Application ref: P/34/13

61 Harbour Road, Pagham – rear extension and conversion of garage to gym

proposed floor plan
1:50

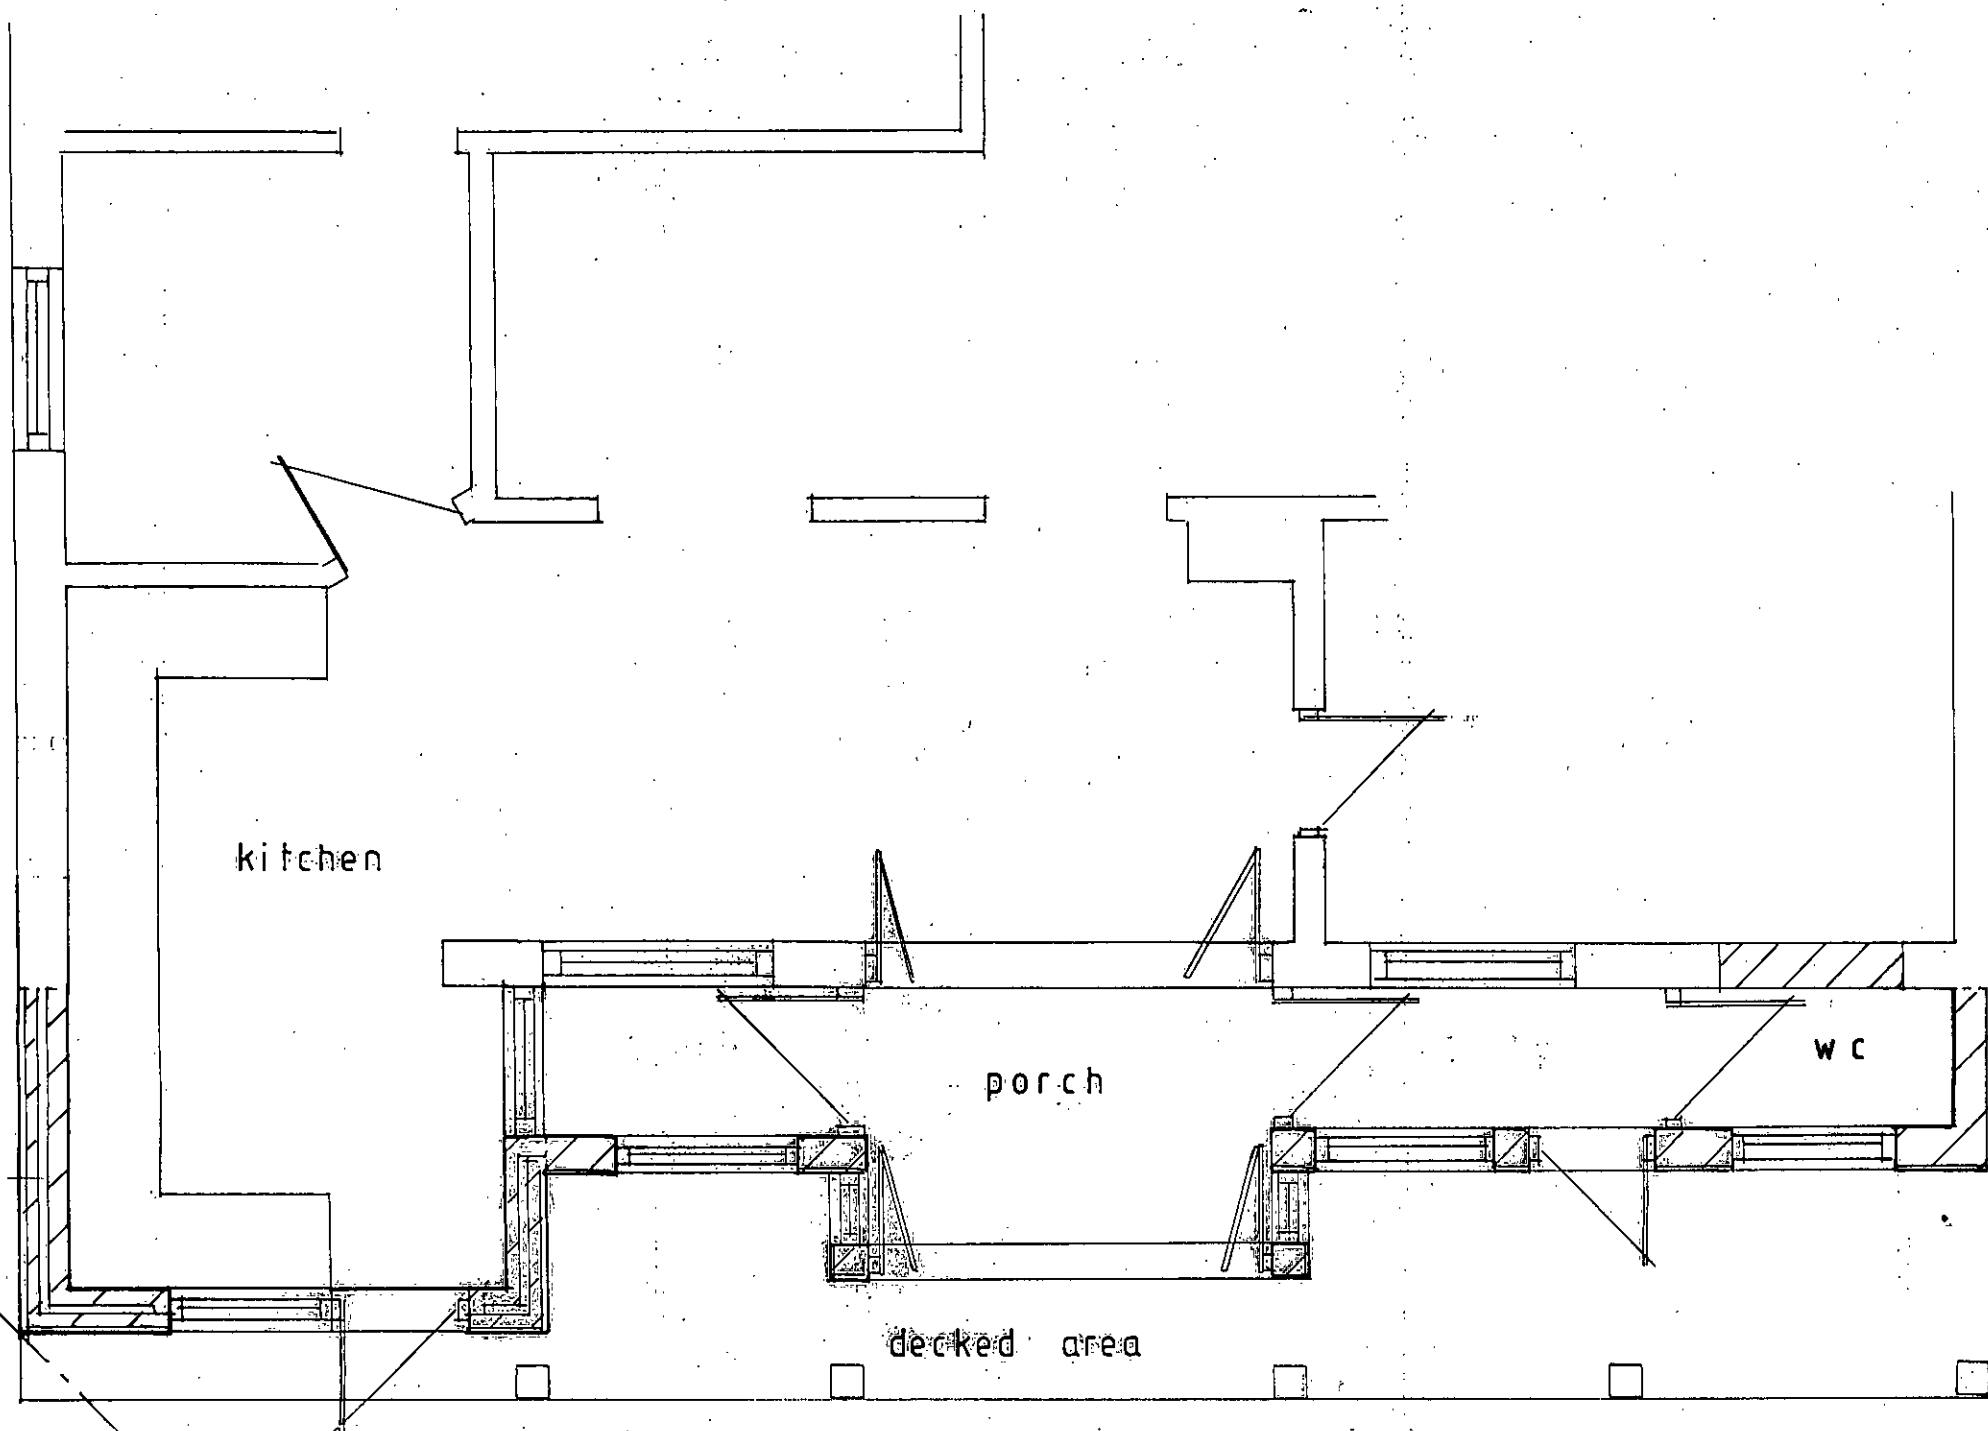
The Company as adjoining owner makes no objection to the proposed extension to the existing bungalow. However, the proposed change of use for the existing garage results in the loss of on-site parking/garaging, and with no alternative on-site parking either from Harbour Road or West Front Road frontage, this will result in roadside parking by residents and visitors to the property in a particularly congested part of the estate, which is unacceptable. I hope you will appreciate that West Front Road is an un-made road of sub-standard width and parked vehicles and stored materials are likely to restrict the width such that access for emergency vehicles cannot be maintained.

In the circumstances, I would urge that the applicant be required to provide adequate on-site parking facilities and that the scheme be amended to reflect this.
